WEST SUSSEX COUNTY COUNCIL CONSULTATION

TO:	Arun District Council FAO: Kathryn Welch
FROM:	WSCC - Highways Authority
DATE:	20 July 2021
LOCATION:	215 Pagham Road, Pagham, PO21 3QD
SUBJECT:	P/104/21/HH Installation of a crossover with drop curb.
DATE OF SITE VISIT:	N/A
RECOMMENDATION:	Advice
S106 CONTRIBUTION TOTAL:	N/A

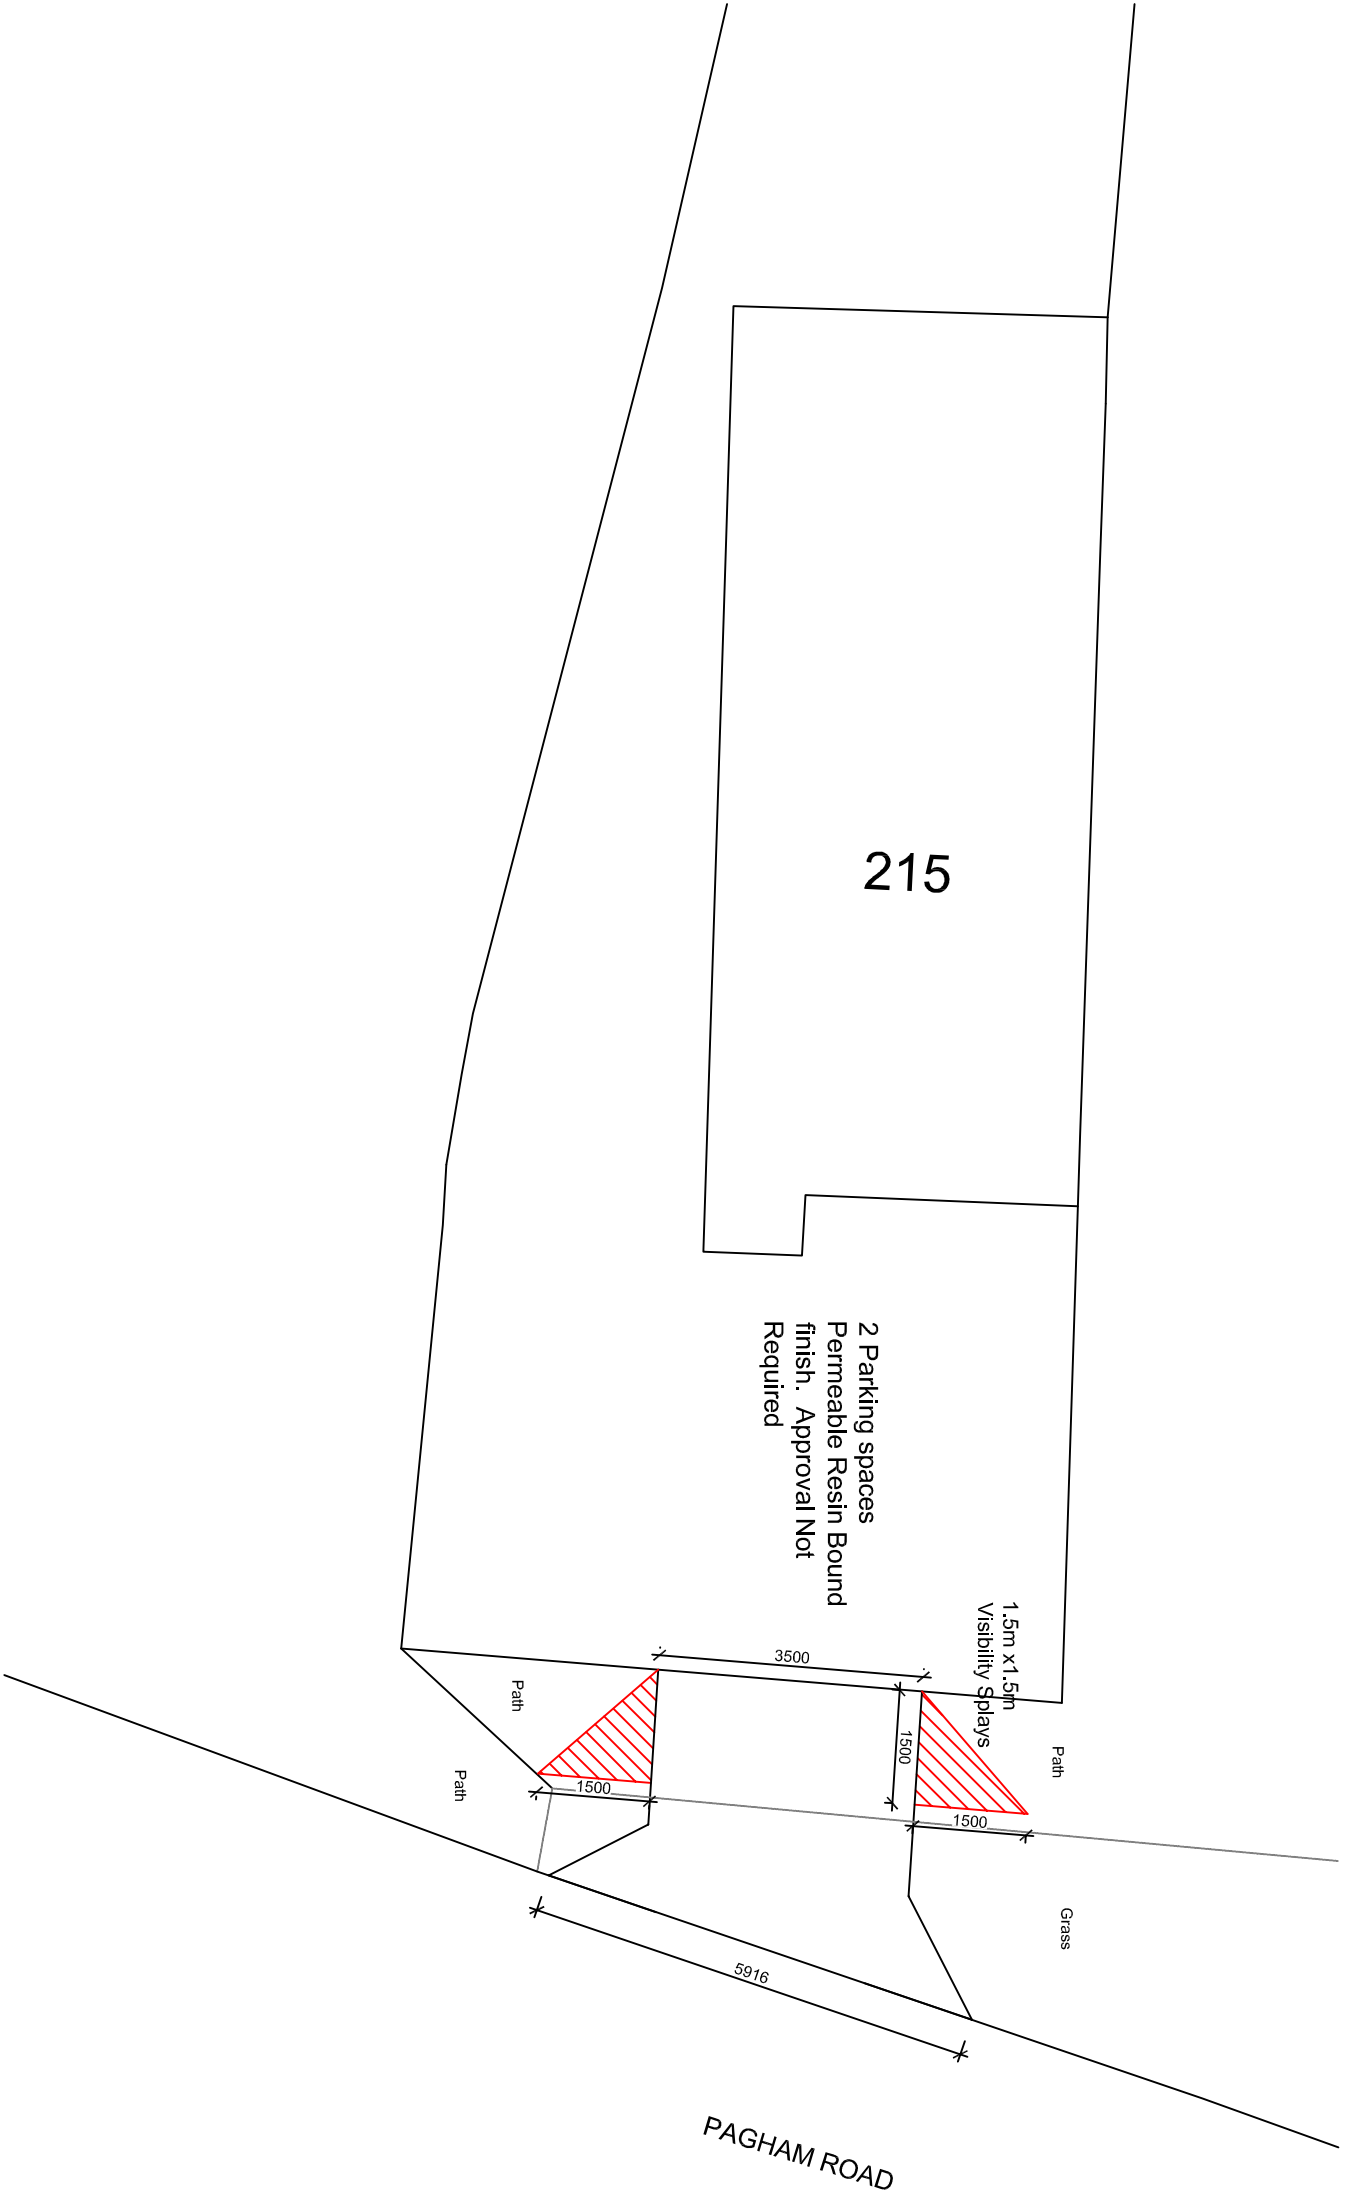
The applicant proposes a new dropped kerb access onto Pagham Road. From inspection of local mapping, there are no apparent visibility issues with the proposed point of access onto Pagham Road. The proposed vehicle crossover (VCO) will be subject to a licence obtained through the local area office and constructed to a specification agreed with the local area engineer.

From inspection of the plans, the parking area fronting the site will be of sufficient size to accommodate two parking spaces. On-site turning does not appear achievable, so cars may have to exit onto Pagham Road in a reverse gear. However, this is not anticipated to result in a highway safety concern.
